jb planning associates

Our Ref: PA/1040/sf
Your Ref: S6/2011/1994/MA

Salisbury Square, Old Hatfield, Herts

Re: Salisbury Square, Old Hatfield, Hertfordshire – Planning Application S6/2011/1994/MA

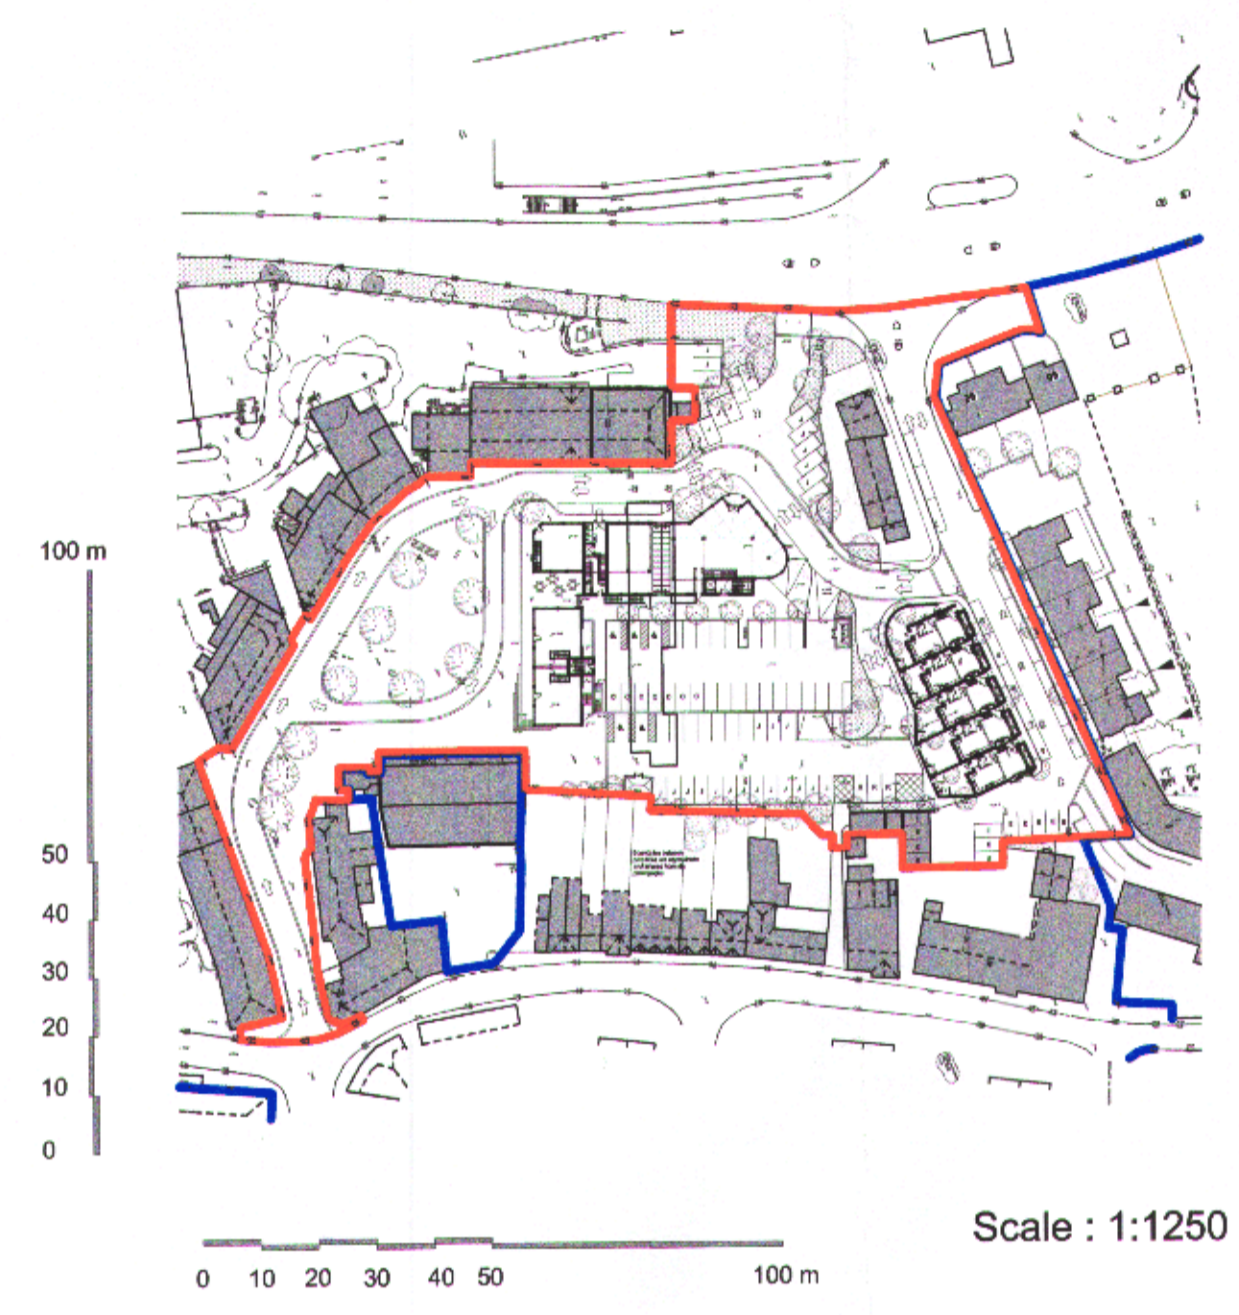
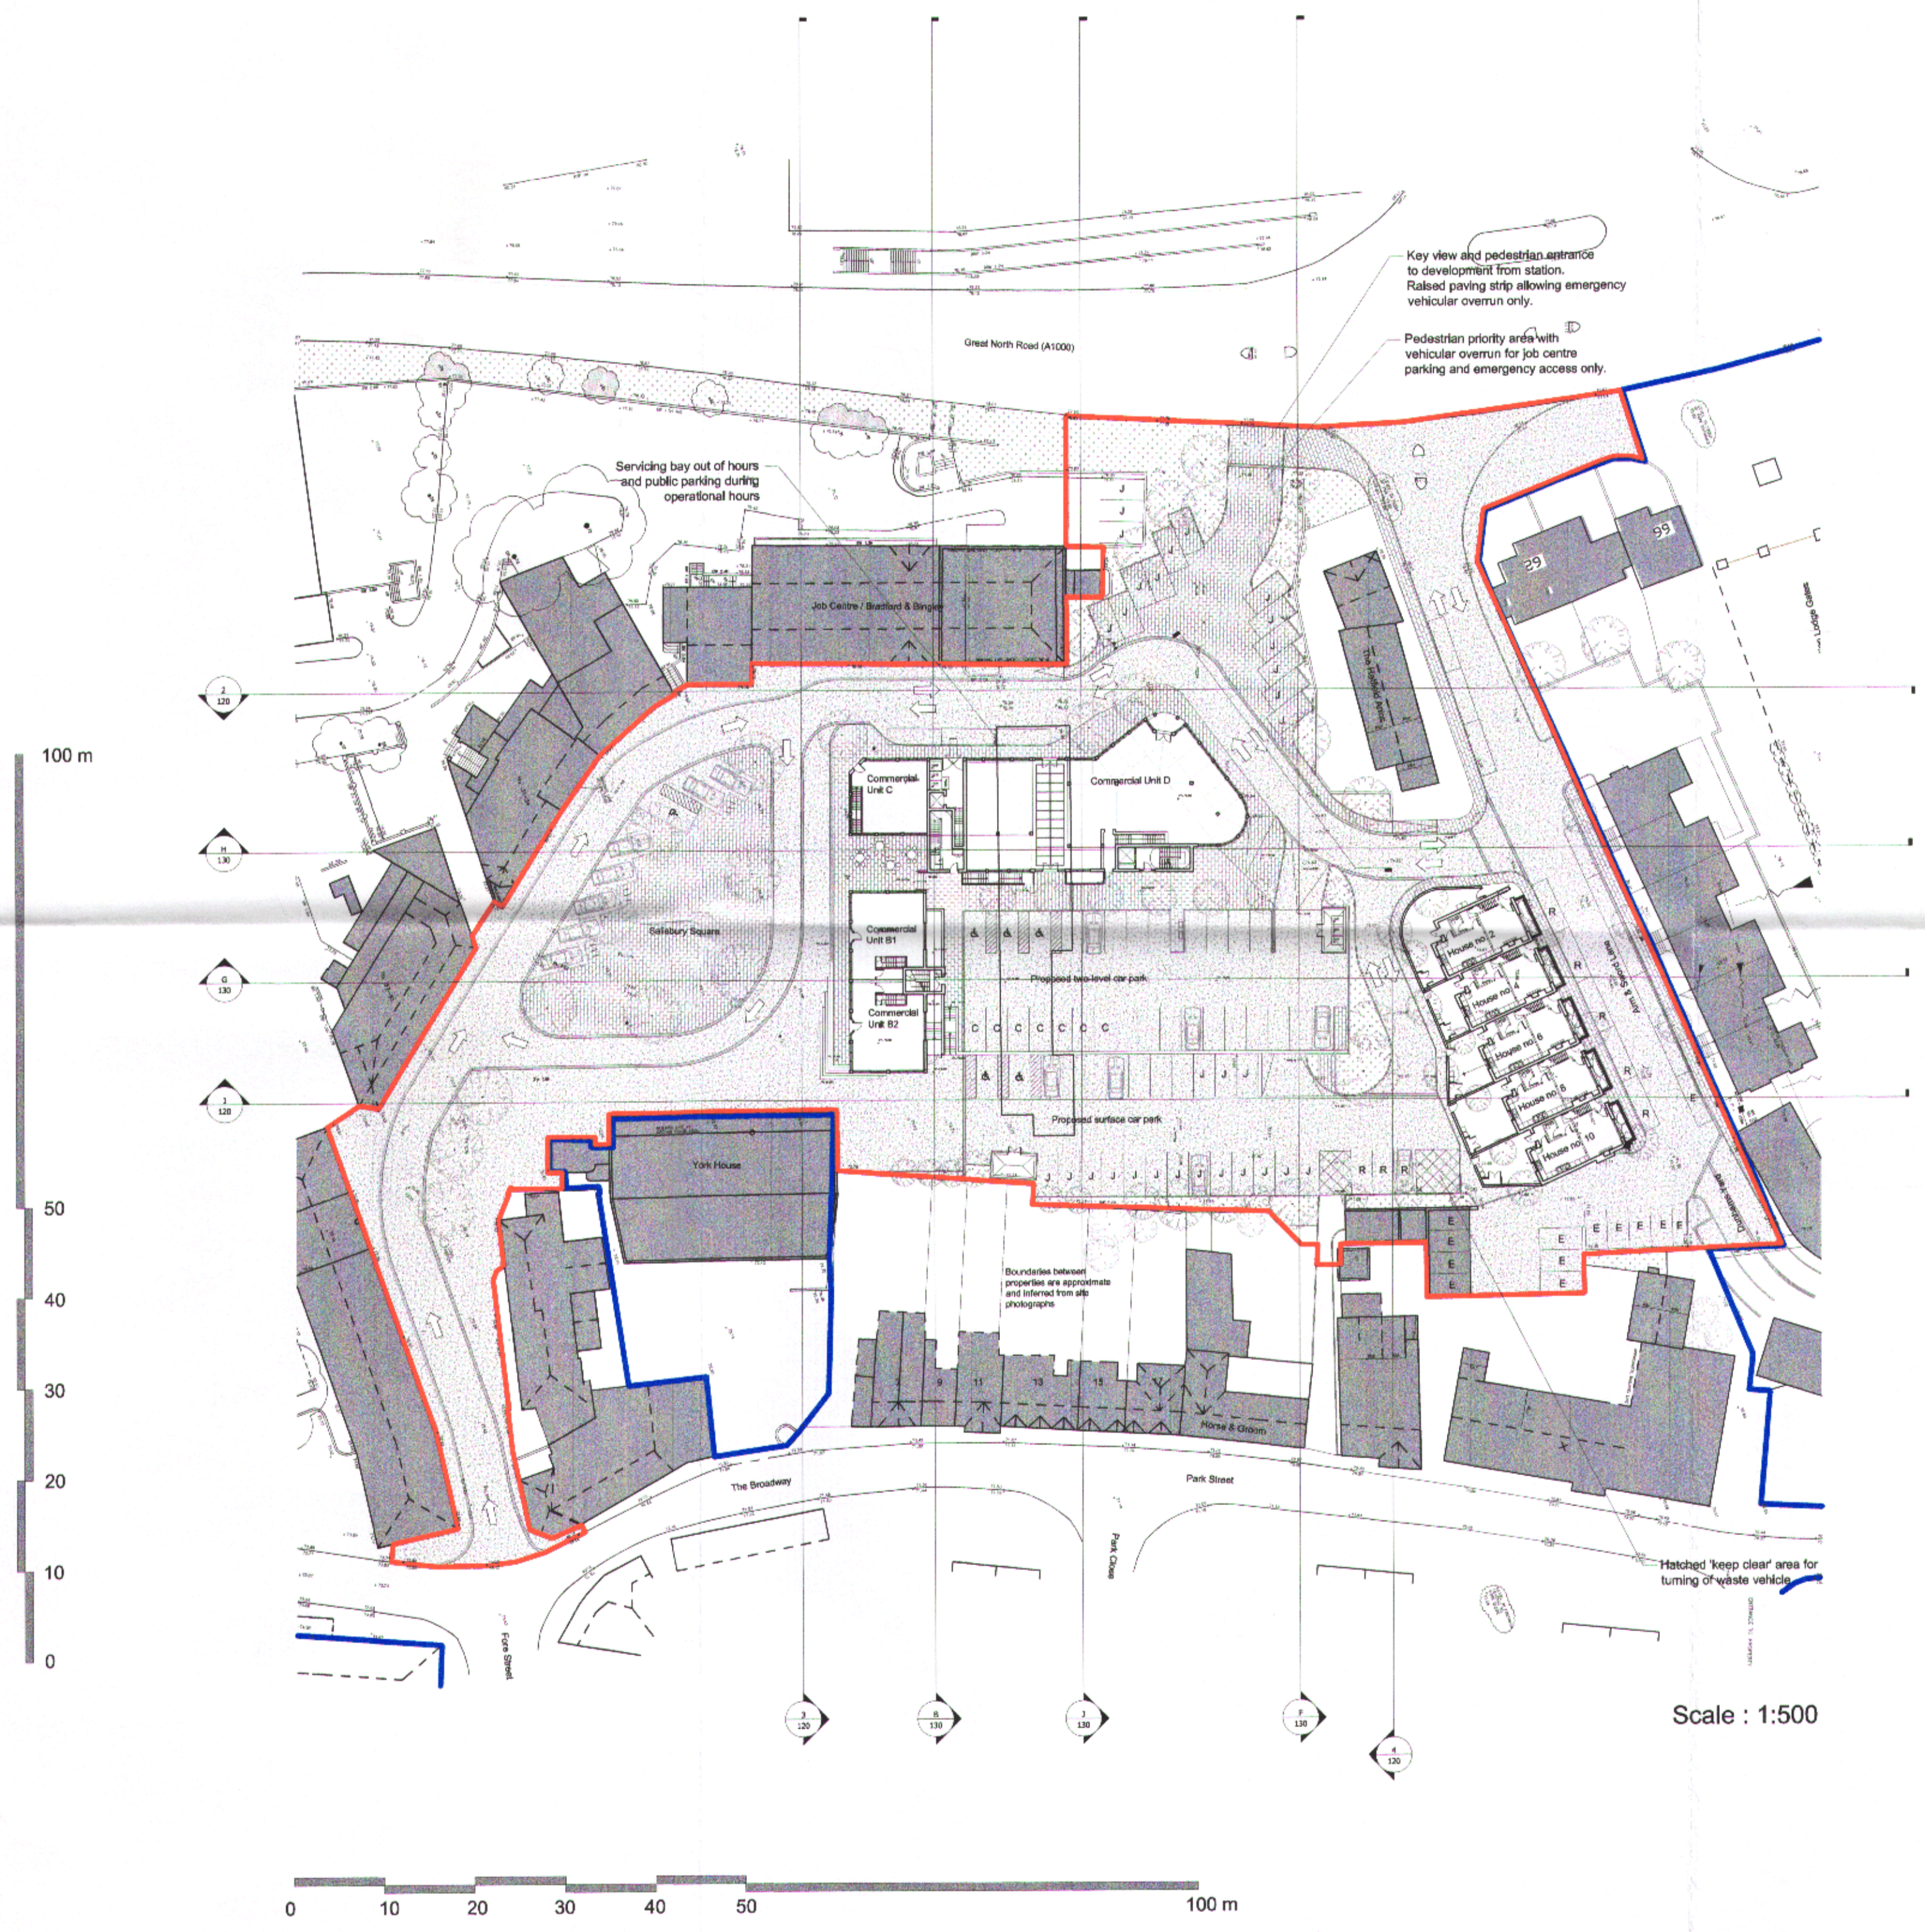
3. **Disabled parking bays** – Six disabled parking bays are proposed, as shown on drawing 789-109 P, which have been distributed around the site to be as close to the principle building entrances as possible and to provide level access to all elements of the scheme.
